ENG-SF21033-R3-GEC.pdf Markup Summary

Subject: Callout
Page Index: 1
Date: 8/25/2022 4:14:12 PM
Author: Daniel Torres
Color: ■
Layer:
Space:
Page Label: [1] 1 CV01

SADDLEHORN RANCH -
FILING 2
COVER SHEET

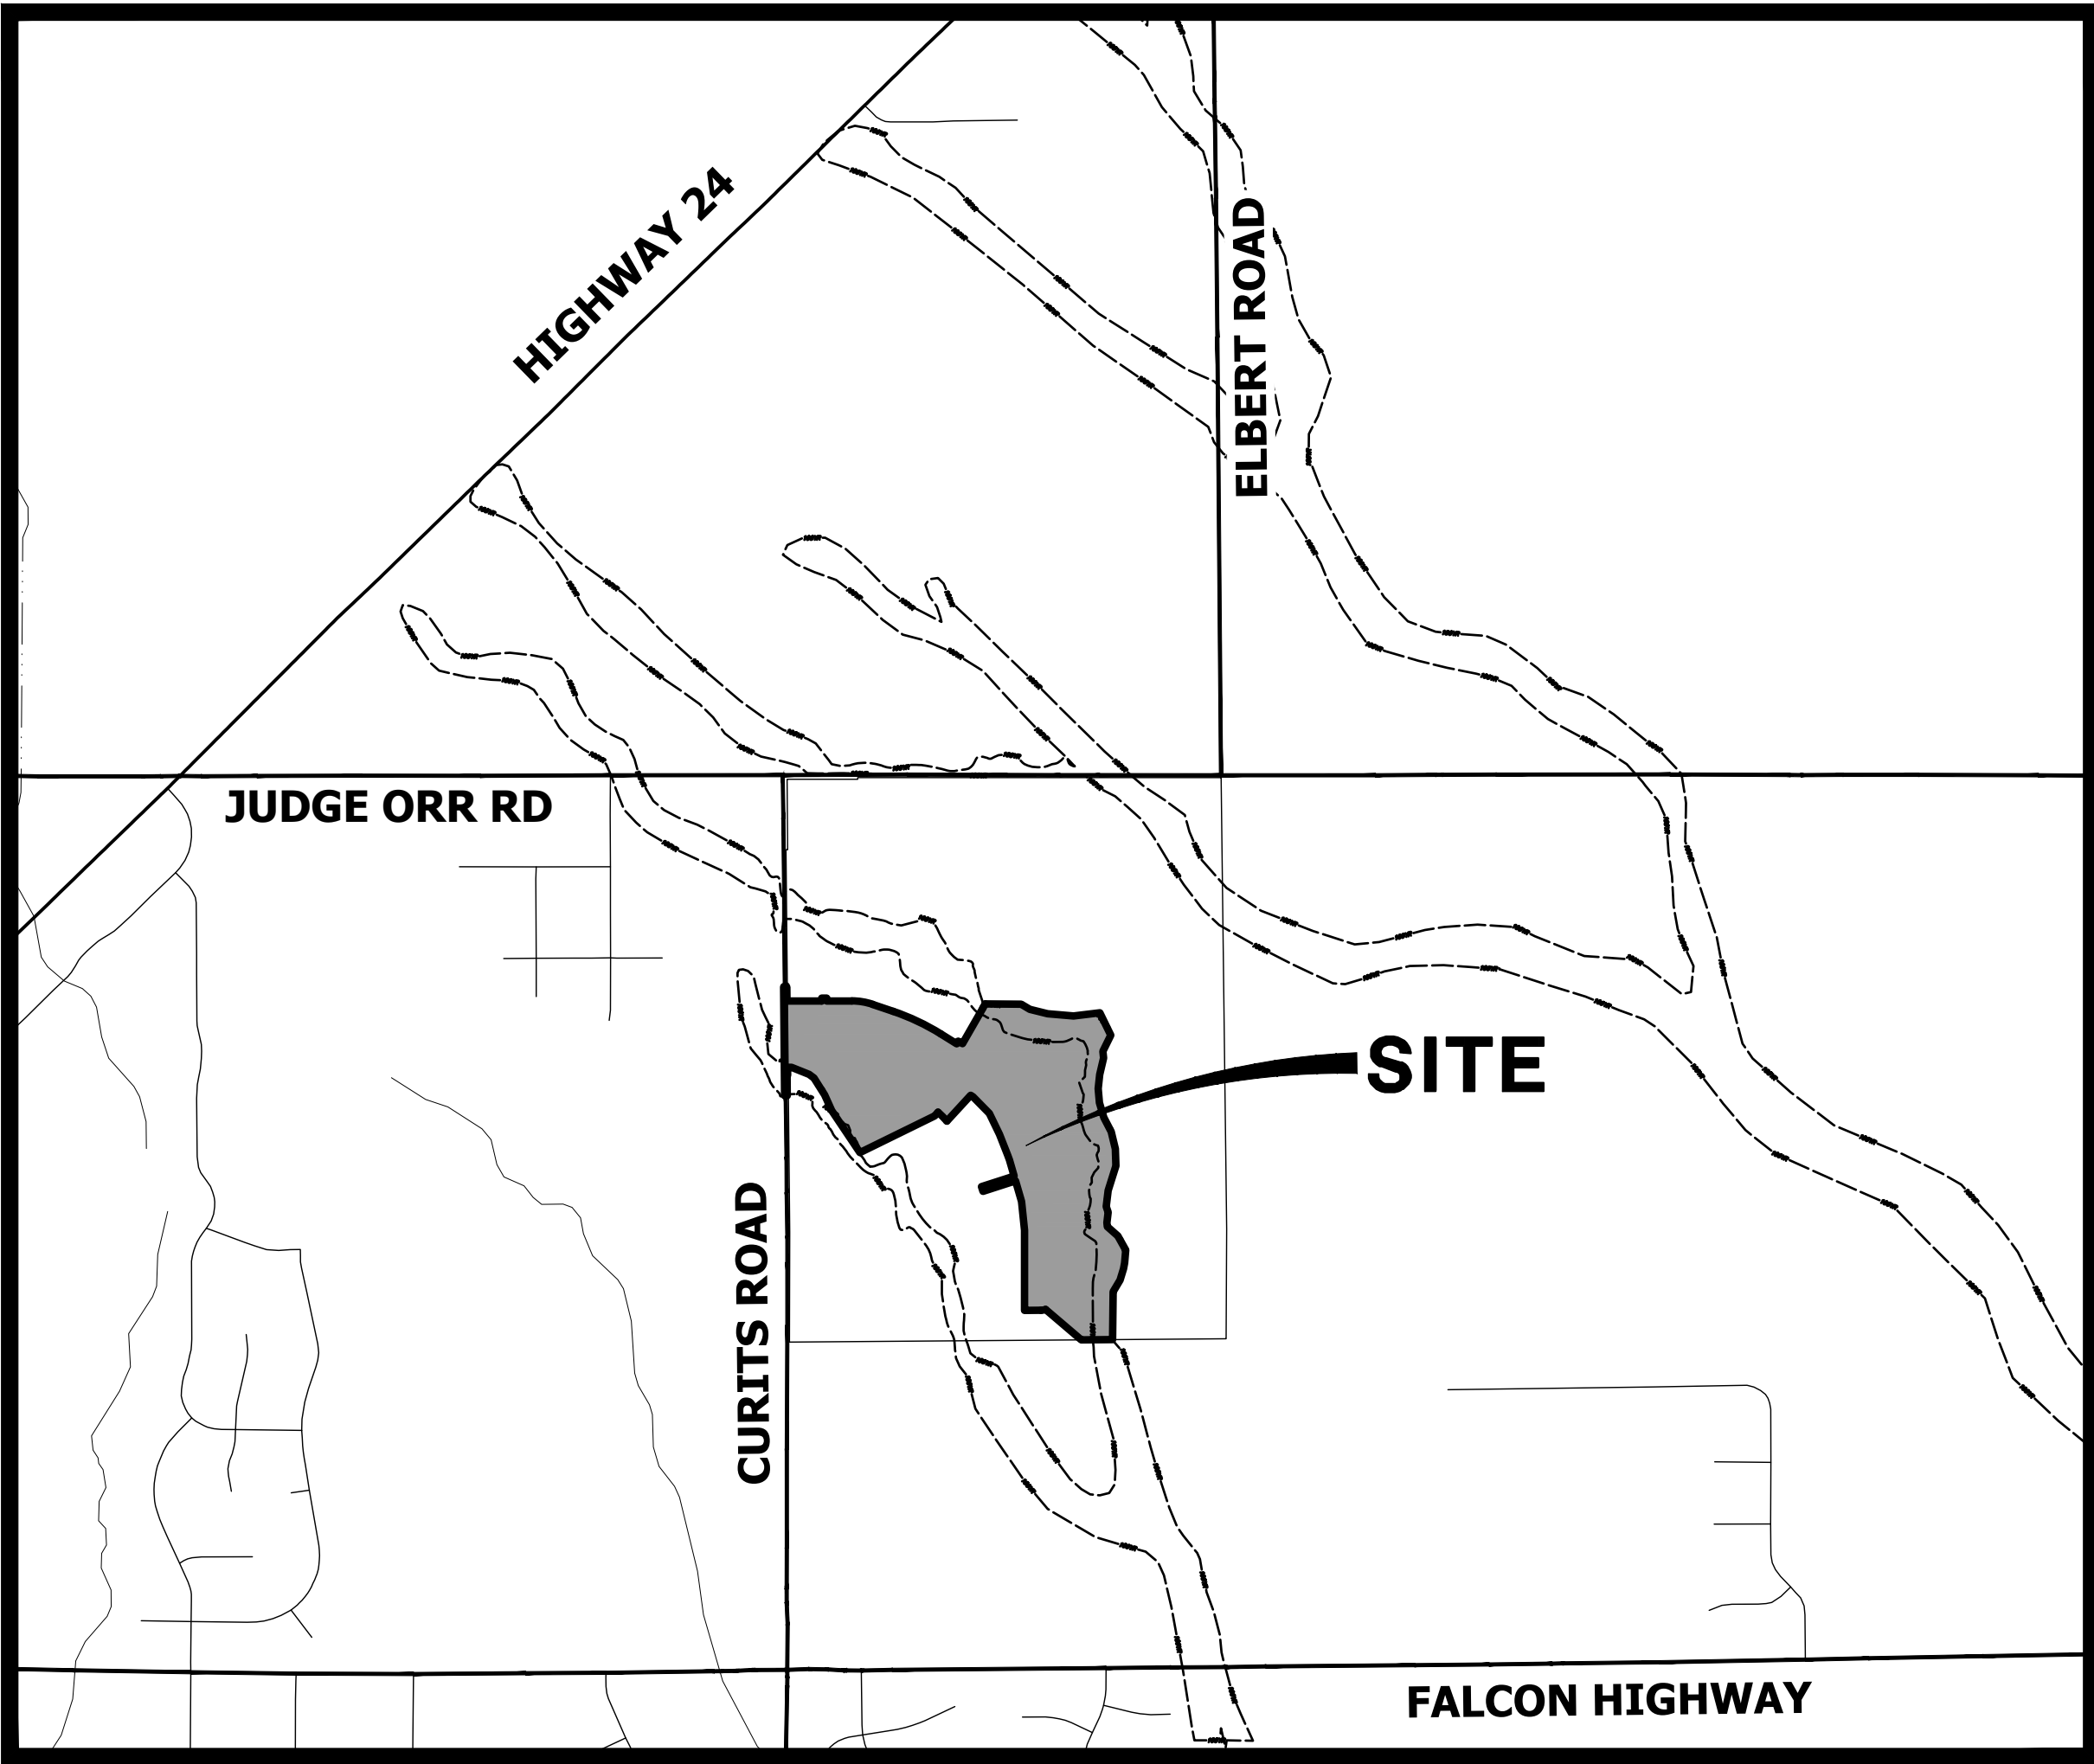
Please revise to SF2133

+
4.1
5-7
8-14

If any channel improvements are needed they will need to be added.

GRADING & EROSION
CONTROL PLANS

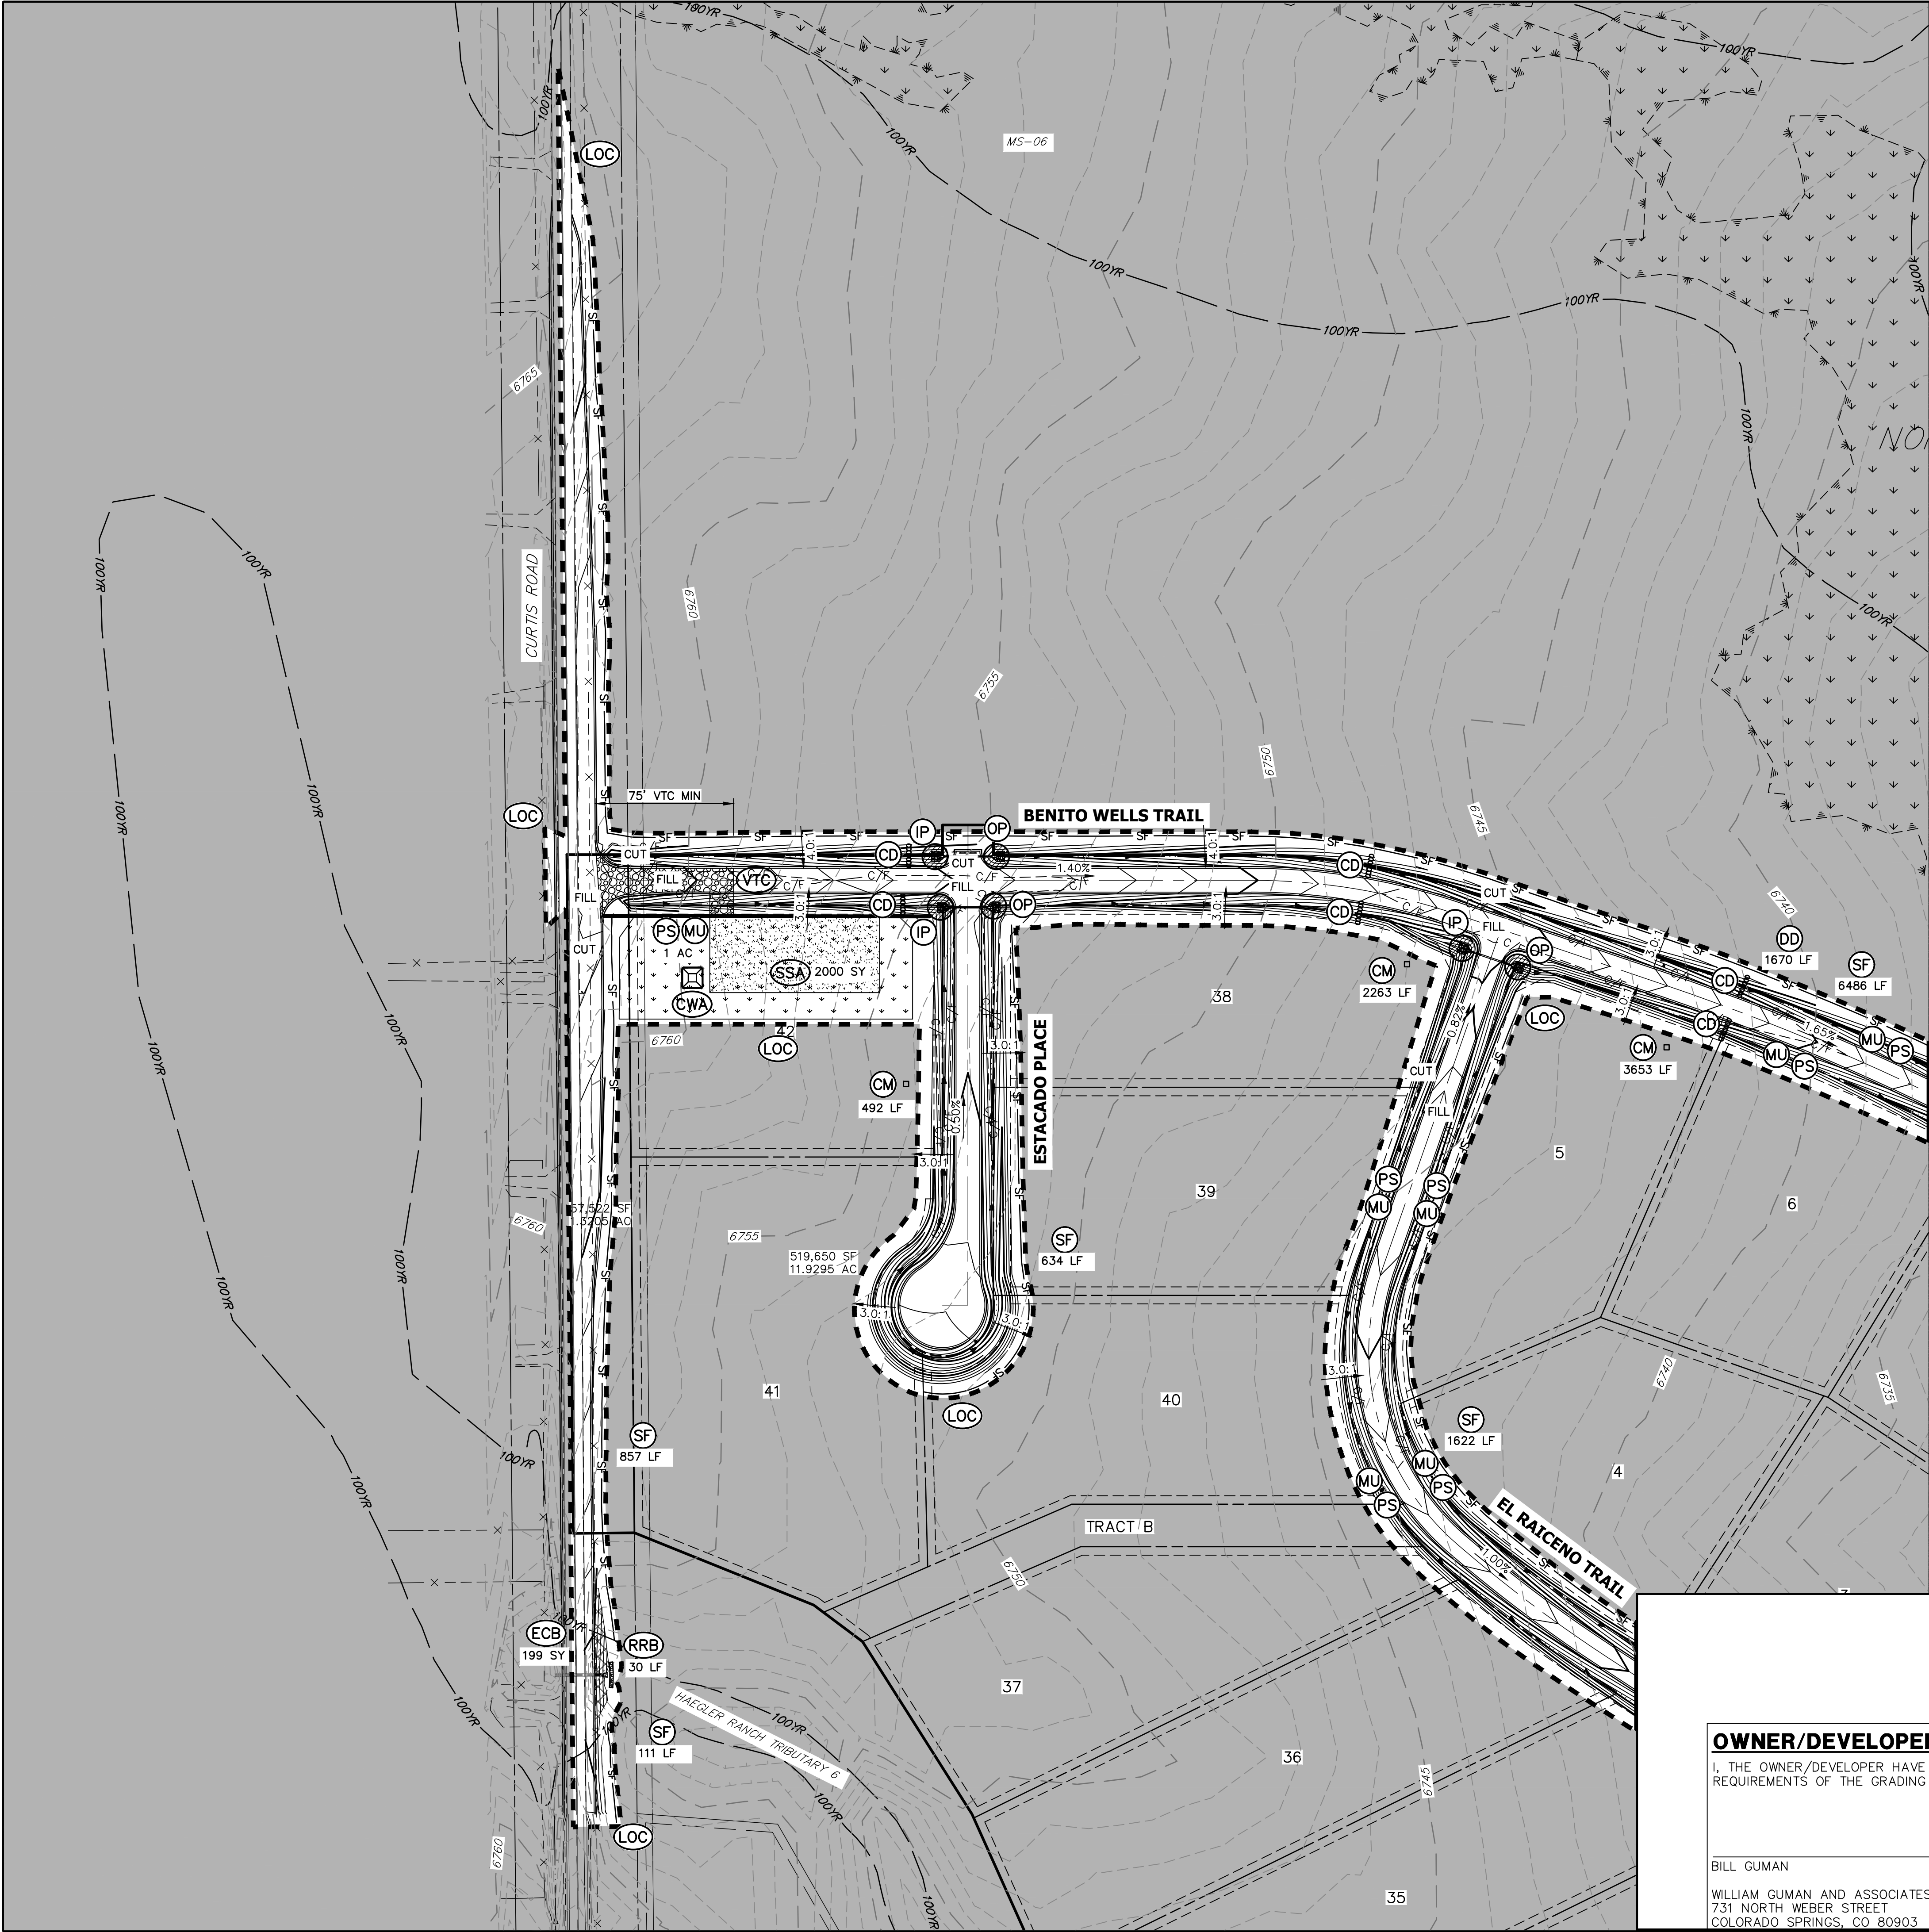
Please update this sheet to match the current one submitted with the EGP application.

SHEET 6 OF 14

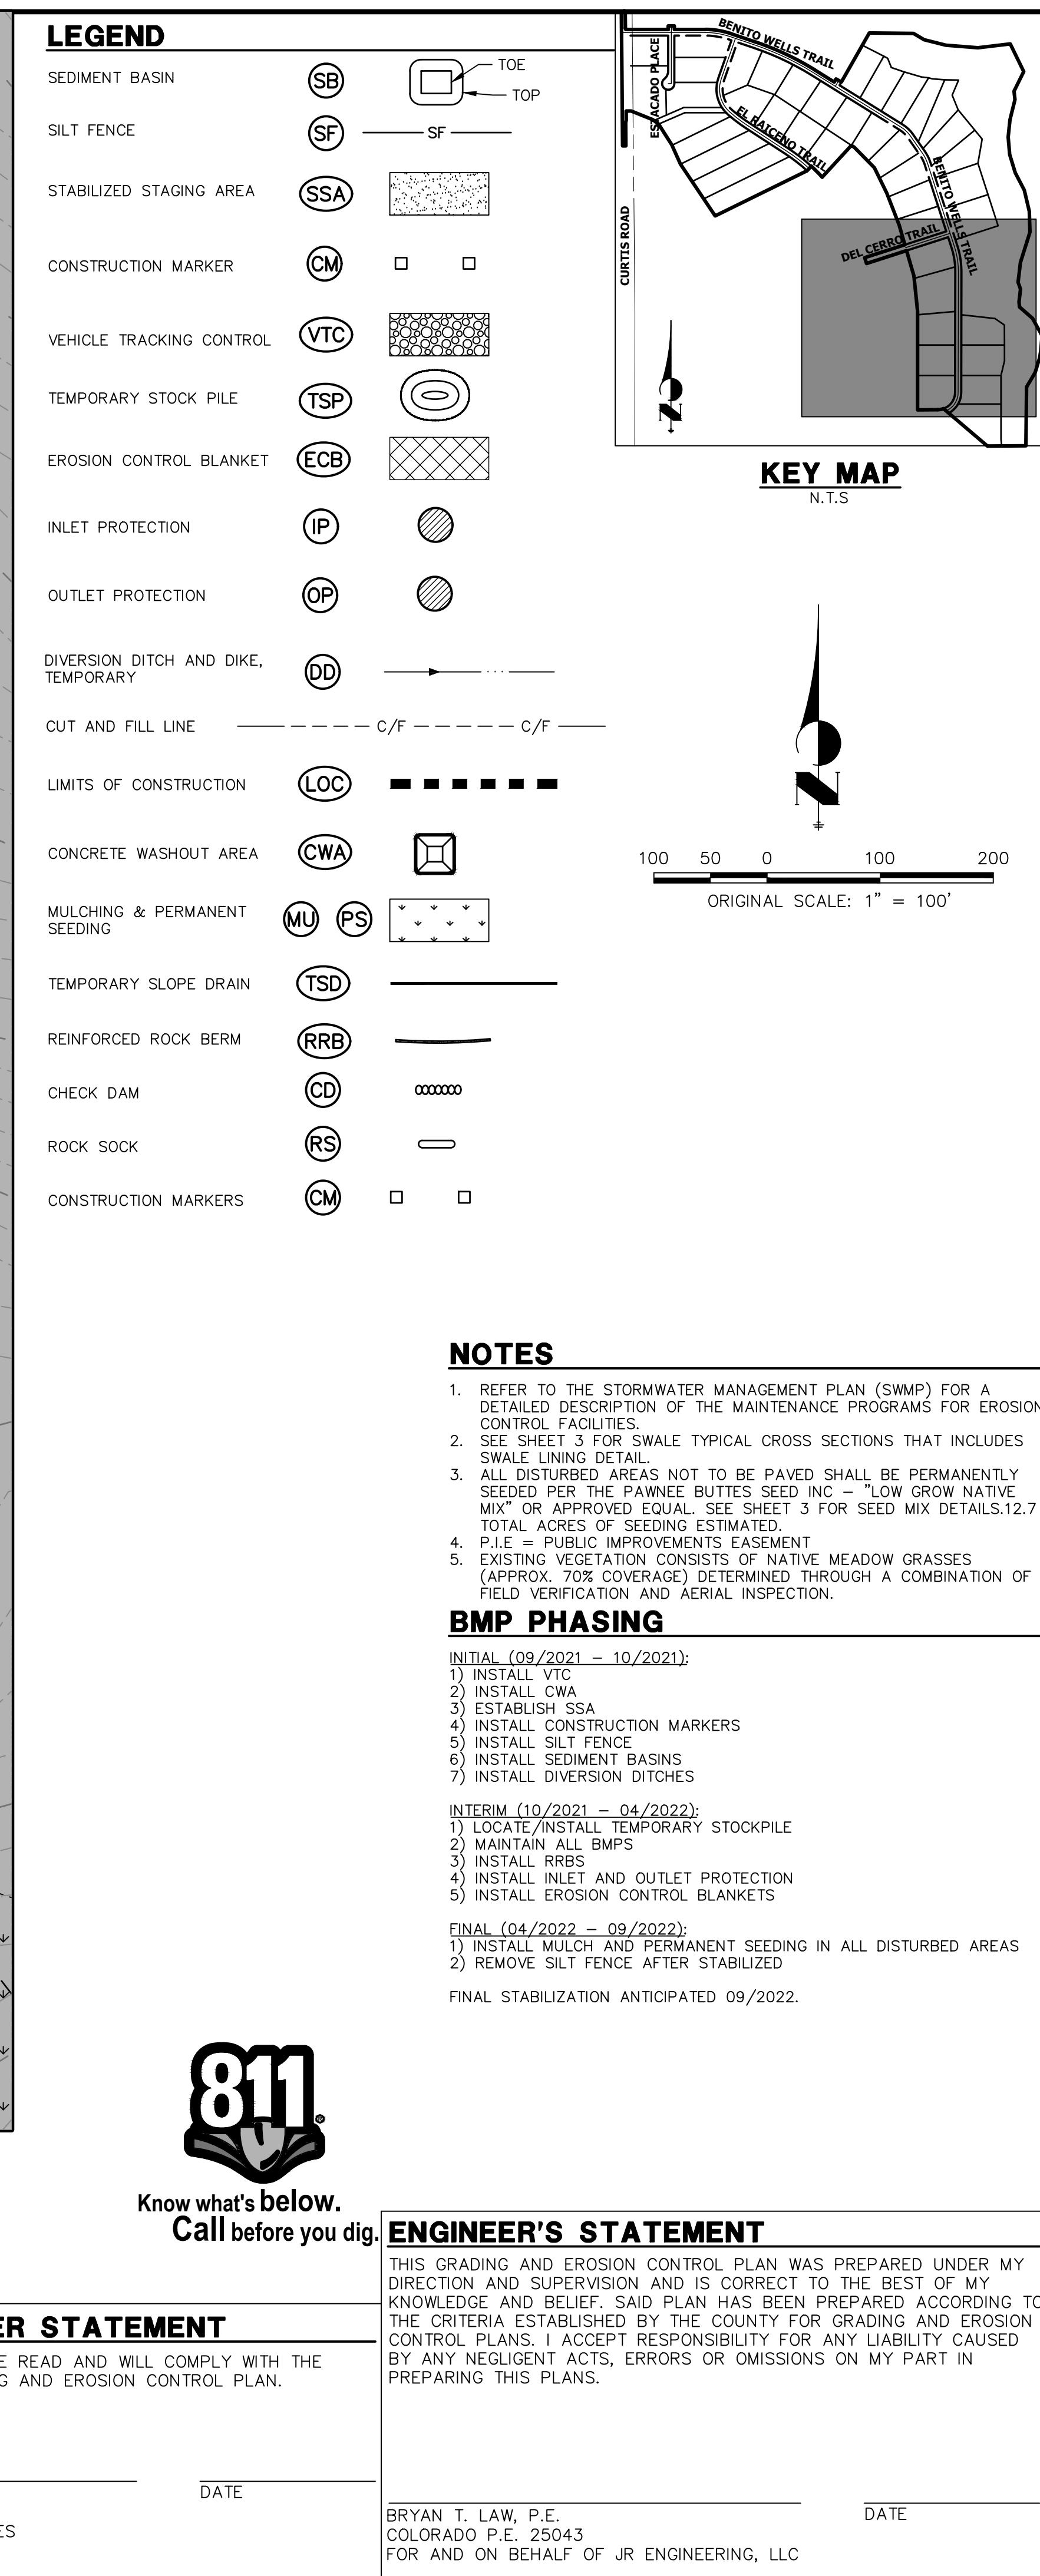
Label all adjacent parcel numbers
